Development Control
Ribble Valley Borough Council

Your ref: 21.0706
Our ref: D3.21.0706
Date: 16th August 2021

Address: Land off Shire Lane, Hurst Green

Proposal: Proposed development of the existing agricultural unit and building into a working farm for breeding of livestock. Proposed new farmhouse with new access

Drawing No.
DRG/03

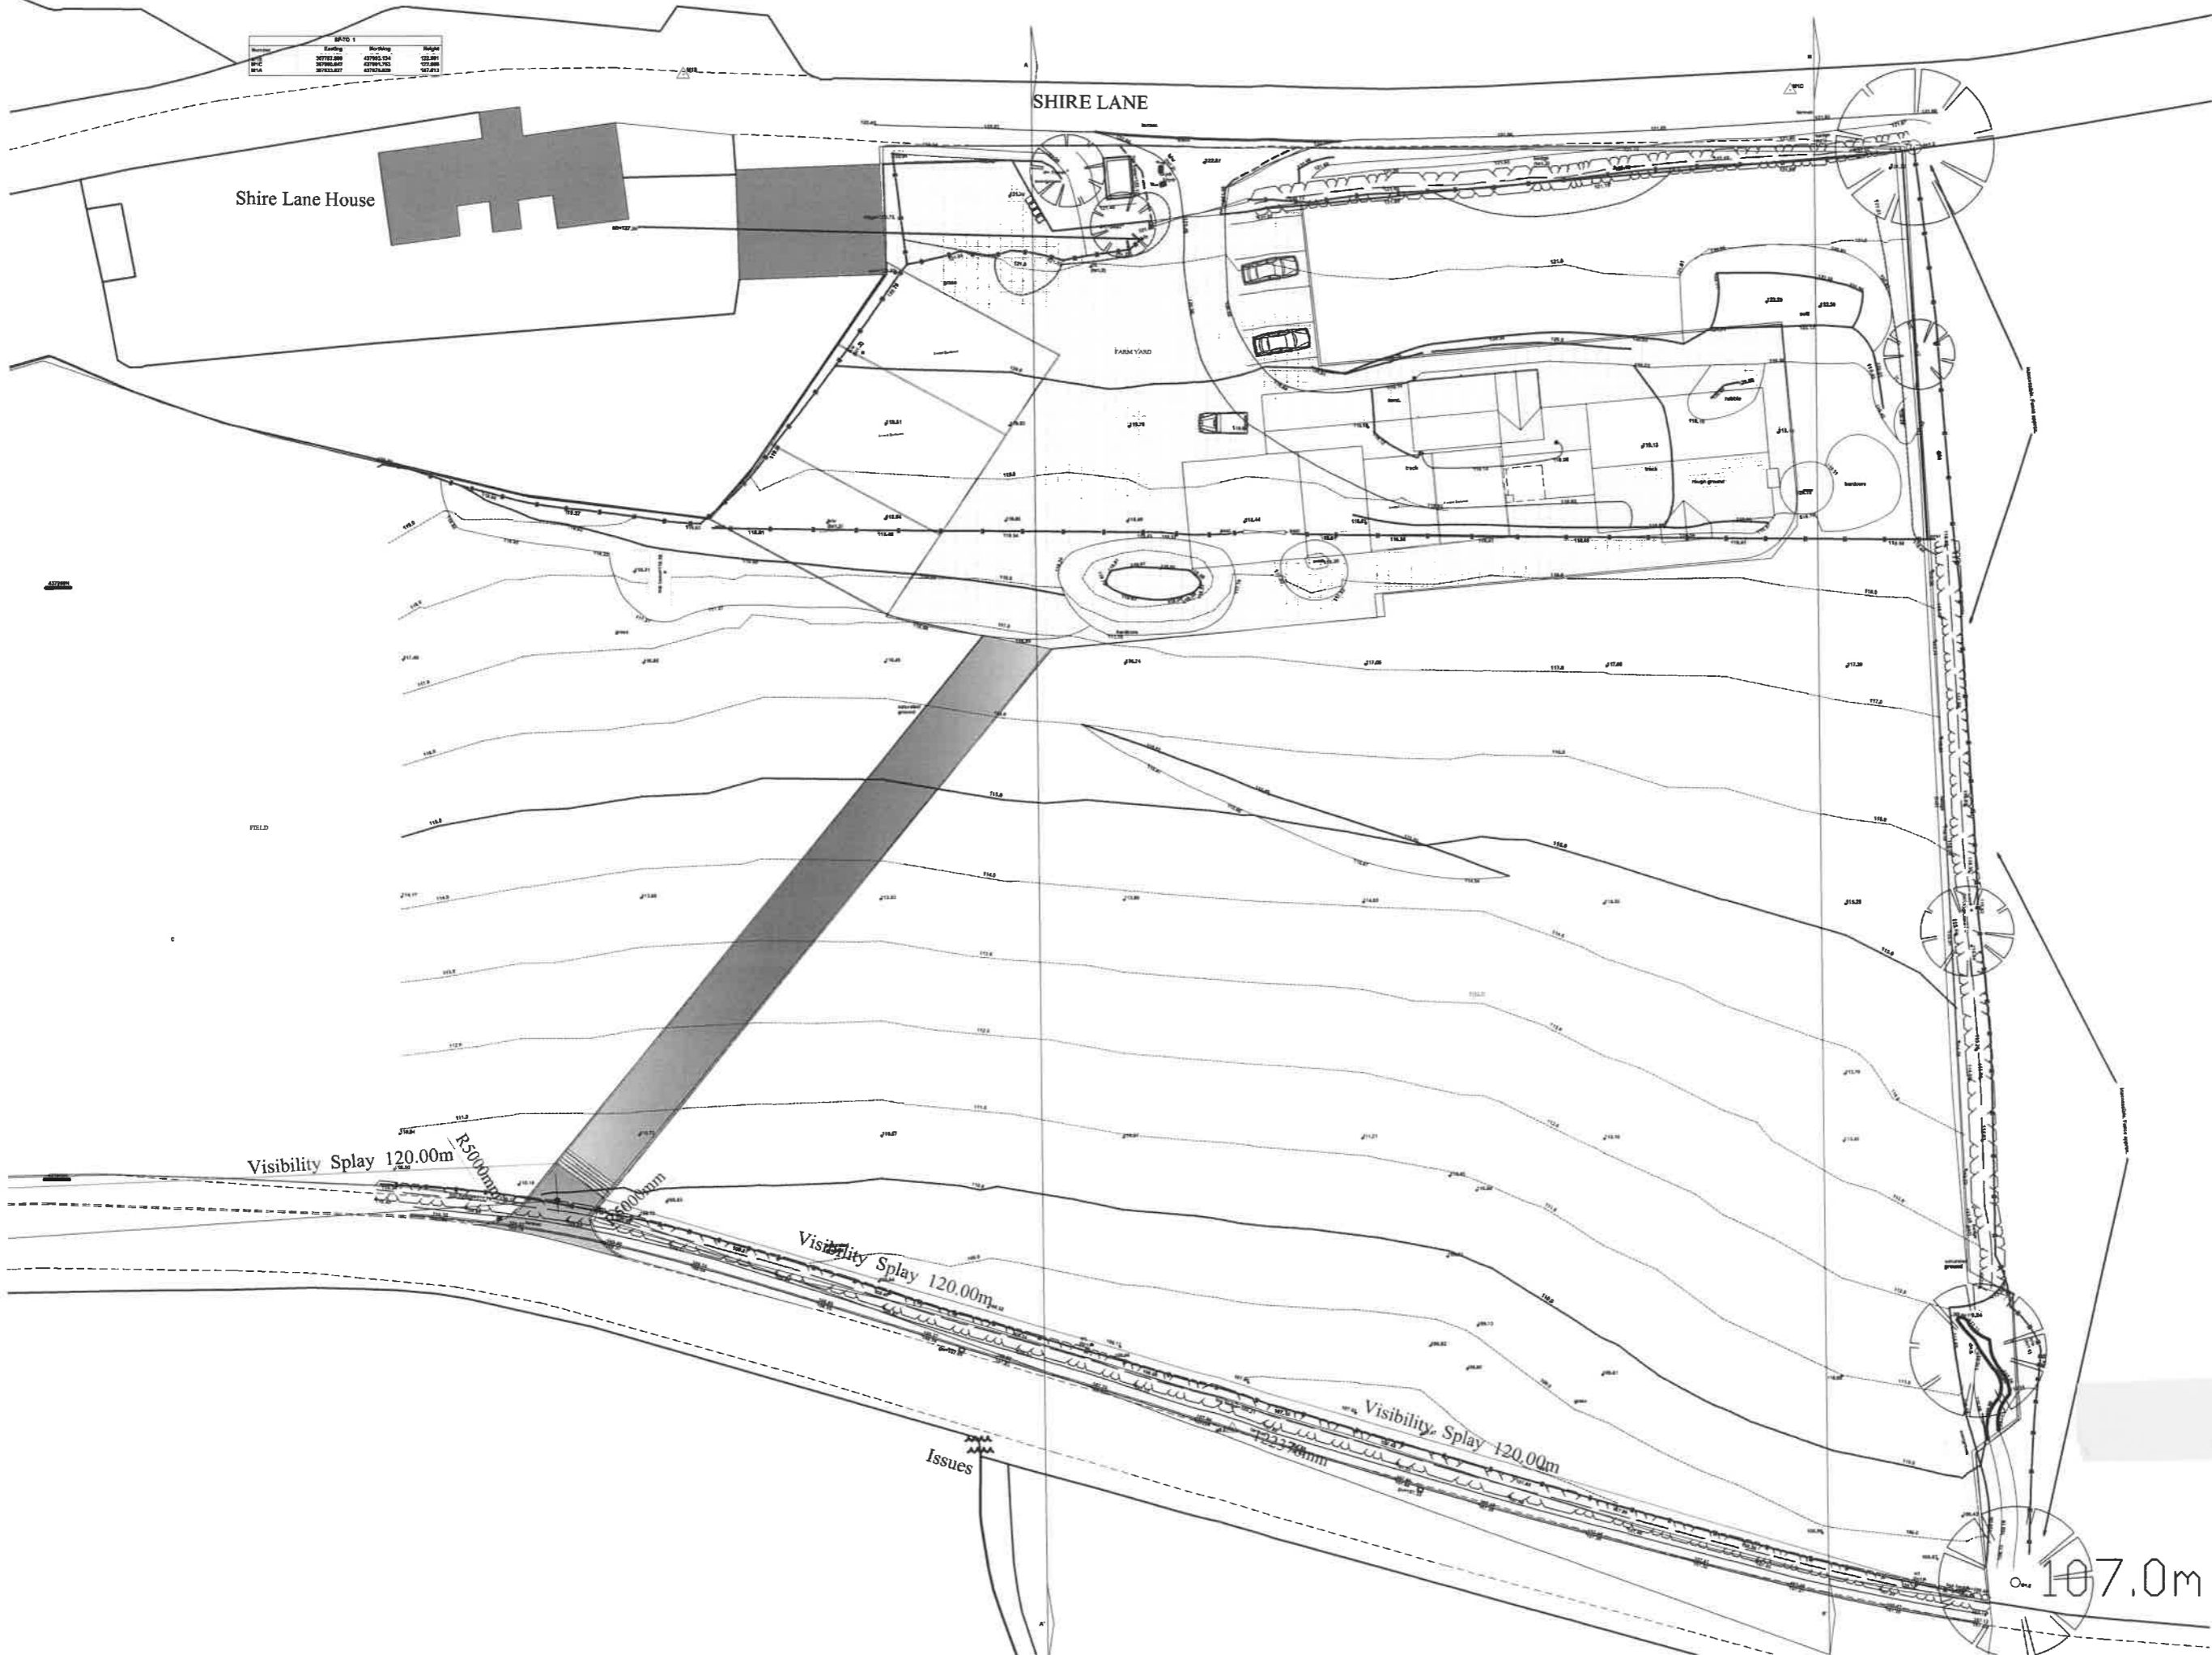
The drawings show visibility splays however they are not clearly drawn from the 2m set back from the edge of carriageway, in both directions for 120m along Longridge Road to the nearside kerb. Please submit a drawing which clearly shows this.

The access road is proposed at 5m wide with 5m kerbed radii. The apron between the carriageway and cattle grid should be paved in a bound material (tarmac ideally) and drained to ensure no surface water drainage flows onto the highway. The apron should be laid relatively flat 1:40. The cattle grid is set back 10m from the edge of carriageway which is acceptable. If the arrangement is amended to gates, then the gates would need to be set back the same distance.

The access road is on a steeply sloping gradient. The cattle grid will capture the surface water and any loose material which is moved along the access road during heavy rainfall. It is recommended that the access road itself is paved in a bound material and the gradient should not exceed 1:12.

Please confirm the visibility splays at the new site access are correctly drawn and are achievable within the adopted highway or land controlled by the applicant.
